From: Kathryn Welch
Sent: 07 October 2025 12:04
To: Planning.Responses
Subject: FW: LU/173/25/PL Arun Self Storage
Attachments: HGV tracking to access and within ASS compound.pdf; Land Drainage Consent.pdf; Land Drainage Consent dwg 6230-2003.pdf; Land Drainage Consent dwgs 6230-2001 & 6230-2002.pdf; Arun Self Storage - vehicle parking layout.pdf; Action Sheet v3 LY.docx

CARAVAN & MOTORHOME SITE PLAN

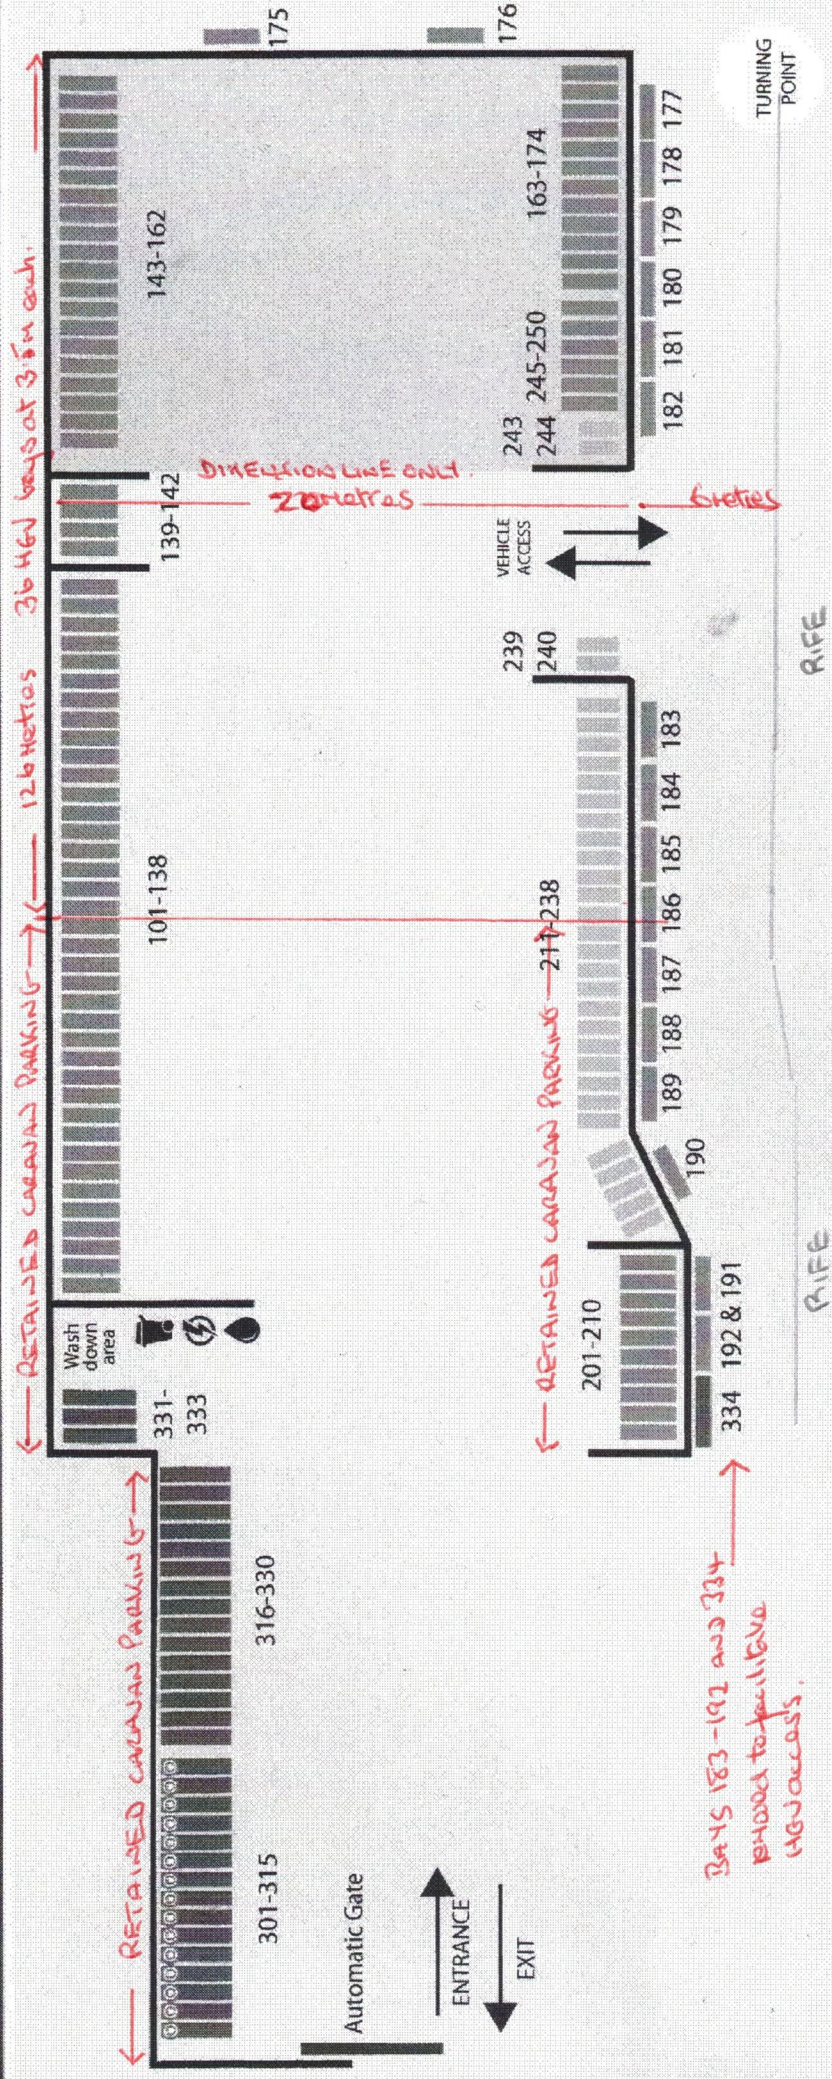
It is not clear from the information provided as to the level of traffic which was previously generated by the existing use of the site as caravan storage for 171 caravans. No has any information been provided on the level of traffic which is likely to be generated by the proposed use. Nor have any layout/parking plans been provided.

- Detailed information of the current/pervious use. Ie nature of operation, traffic generation levels
- Detailed information of the proposed use. Ie nature of operation, traffic generation levels
- A site plan showing parking and turning spaces (including track plots)
- An access plan including track plots.
- In the event traffic levels (especially of HGV type vehicles) are significantly greater than existing we may request additional junction analysis or more detailed transport modelling.

4. Vehicle bays are all marked out. I attach our illustrative bay layout. Bays for the 5.6m and 7.4m caravans are 3m in width whilst those for the 11m caravans are 3.5m in width.

5. The application seeks to permit larger vehicles to use the site. It is anticipated that the site would have a mixed use, retaining bays 301-333 and bays 101-120 and 201- 227 for caravan storage with the remainder used for commercial vehicles which would, in the most part, comprise 12m rigid vehicles such as used by removals and/or delivery firms. In that event the bays alongside the drainage rife, numbers 177-192 and number 334 would be removed from use as would bays 228-250 and 163-174.
Bays 121- 162 (all 3m wide) would be converted to rigid vehicle use. Hence 42 rigid vehicles. In this anticipated event, daily movements in and out of the site are anticipated as to caravans/motorhomes (3) , rigid lorries (21) = 24 in total in any 24 hour period, rising to caravans/motorhomes (9) , rigid lorries (21) = 30 in total during late Spring and the Summer.
